Please find attached two documents which contain Comments on Responses to ExA Written Questions 1 on responses from the Applicant to questions relating to:

Comments on responses to Examiners Questions 1: Surplus Generation, Battery Storage, Need and Very Special Circumstances.

Comments on ExQ1 Responses - Residential Visual Amenity Assessment (RVAA) and Glint and Glare

**A selection of photographs and montages from the 20 properties requesting an ExA visit.**

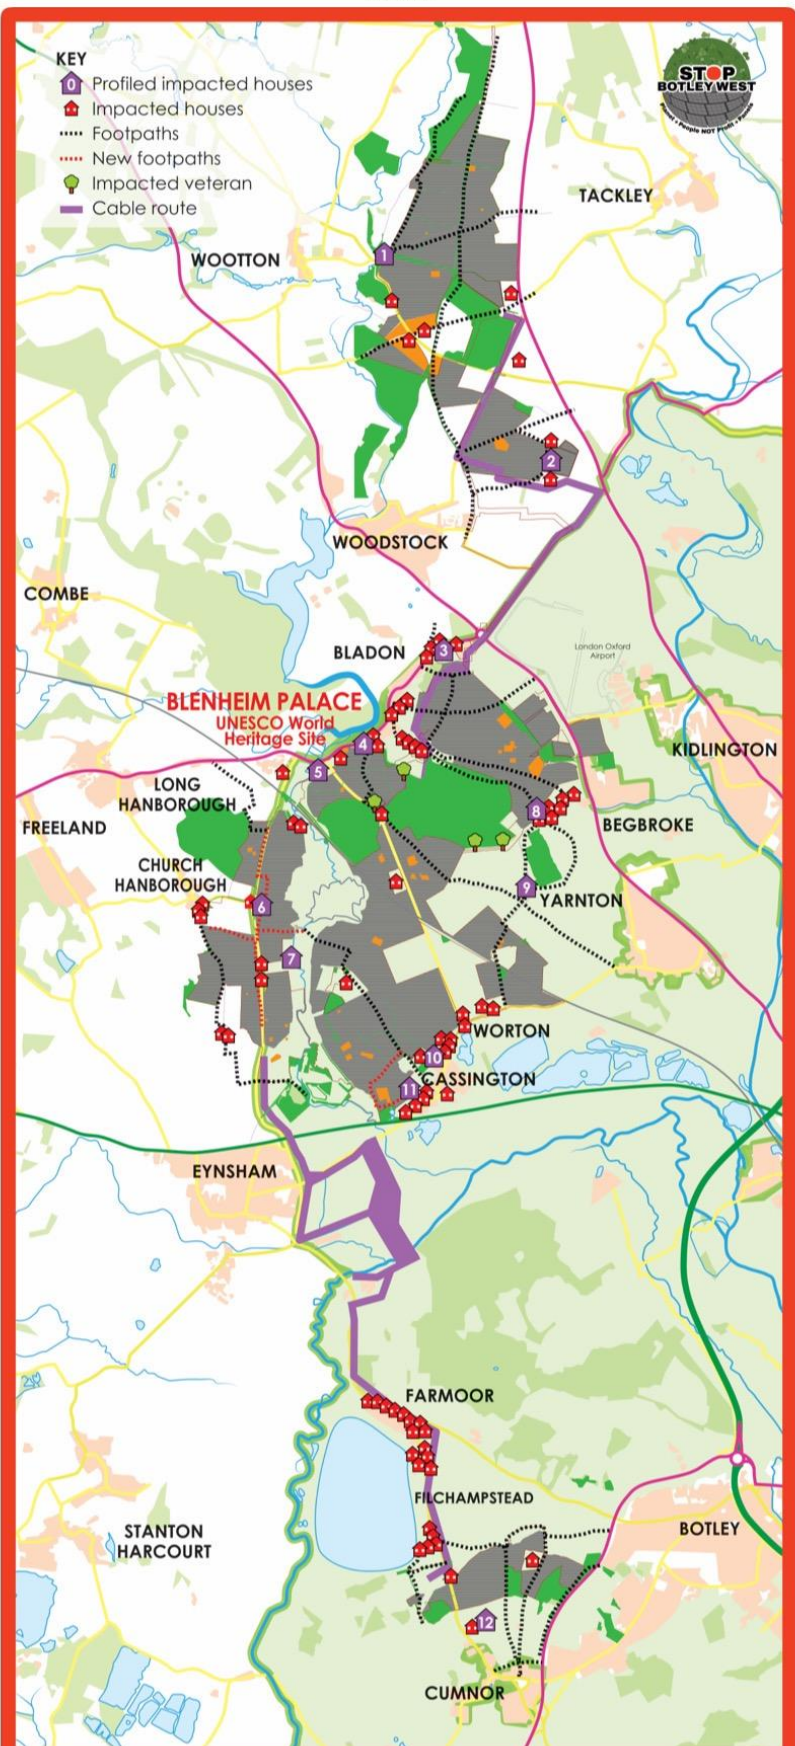
- 1.9. I can personally attest, having visited nearly all of the impacted properties/settlements within 100m of the site, that most do not have existing vegetation affording any screening from the panel area. Additionally, due to the steep contours in the Central and Southern sites, NO amount of hedging or fencing would screen the views for many properties eg all those along Lower Road, Church Hanborough or on Tumbledown Hill, Cumnor and for some of the properties in Bladon, Cassington and Begbroke.

- 1.10. A sample of around 20 of the most impacted property owners have requested an ASI so that ExA can judge for themselves the level of impact on Residential Amenity involved.
